From: Paul Airey [REDACTED]
Sent: 12 April 2018 16:01
To: Daun Johnson
Subject: Re: A/44/18/PL The Vinery, Poling

From: Daun Johnson
Sent: Thursday, April 12, 2018 2:07 PM
To: [REDACTED]
Subject: A/44/18/PL The Vinery, Poling

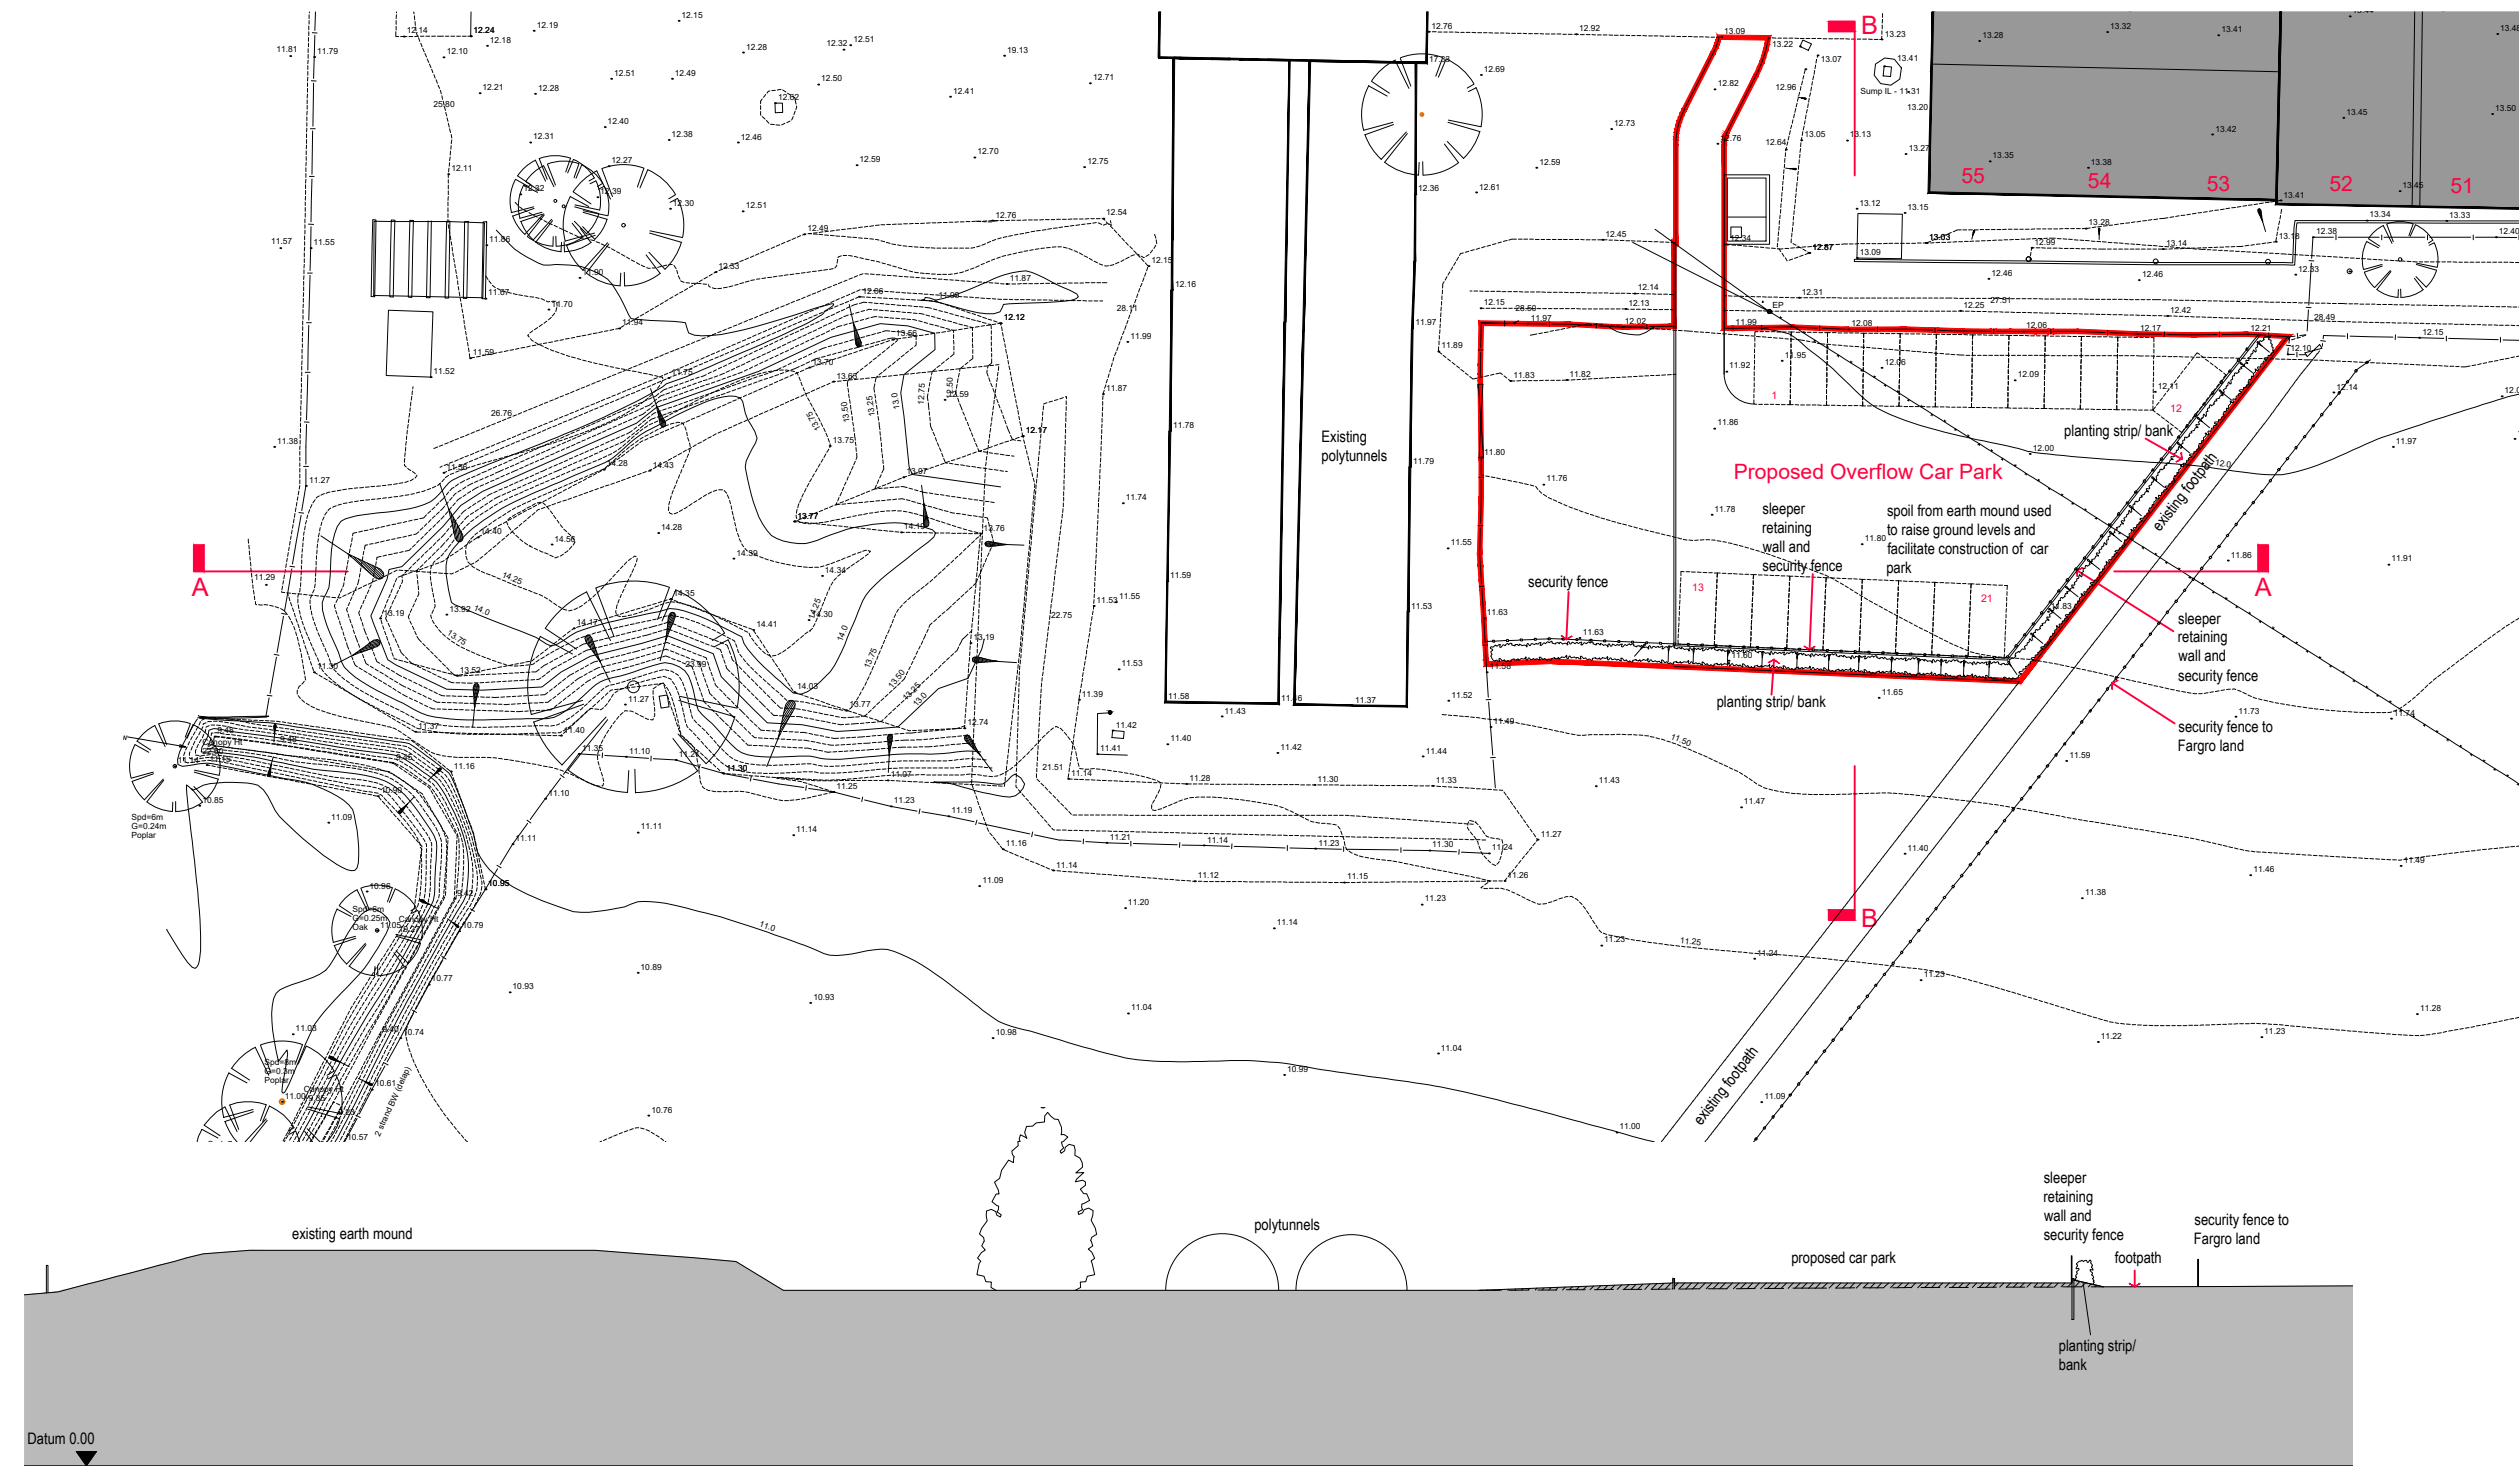
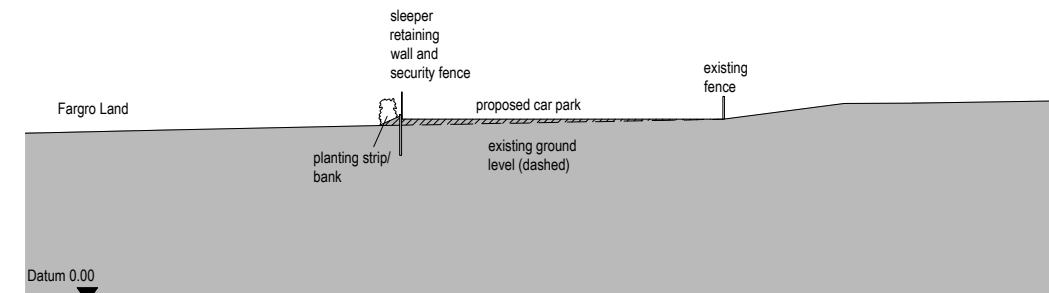
Can you please confirm the height of the fence and retaining wall?

Dear Ms Johnson, The security fence is 1.8m high above the level of the car park, with the retaining wall projecting up 300mm above the car park level to the outside of the fence. The top of the retaining wall is 700mm above existing ground levels where section BB cuts through, and 545mm at section AA.
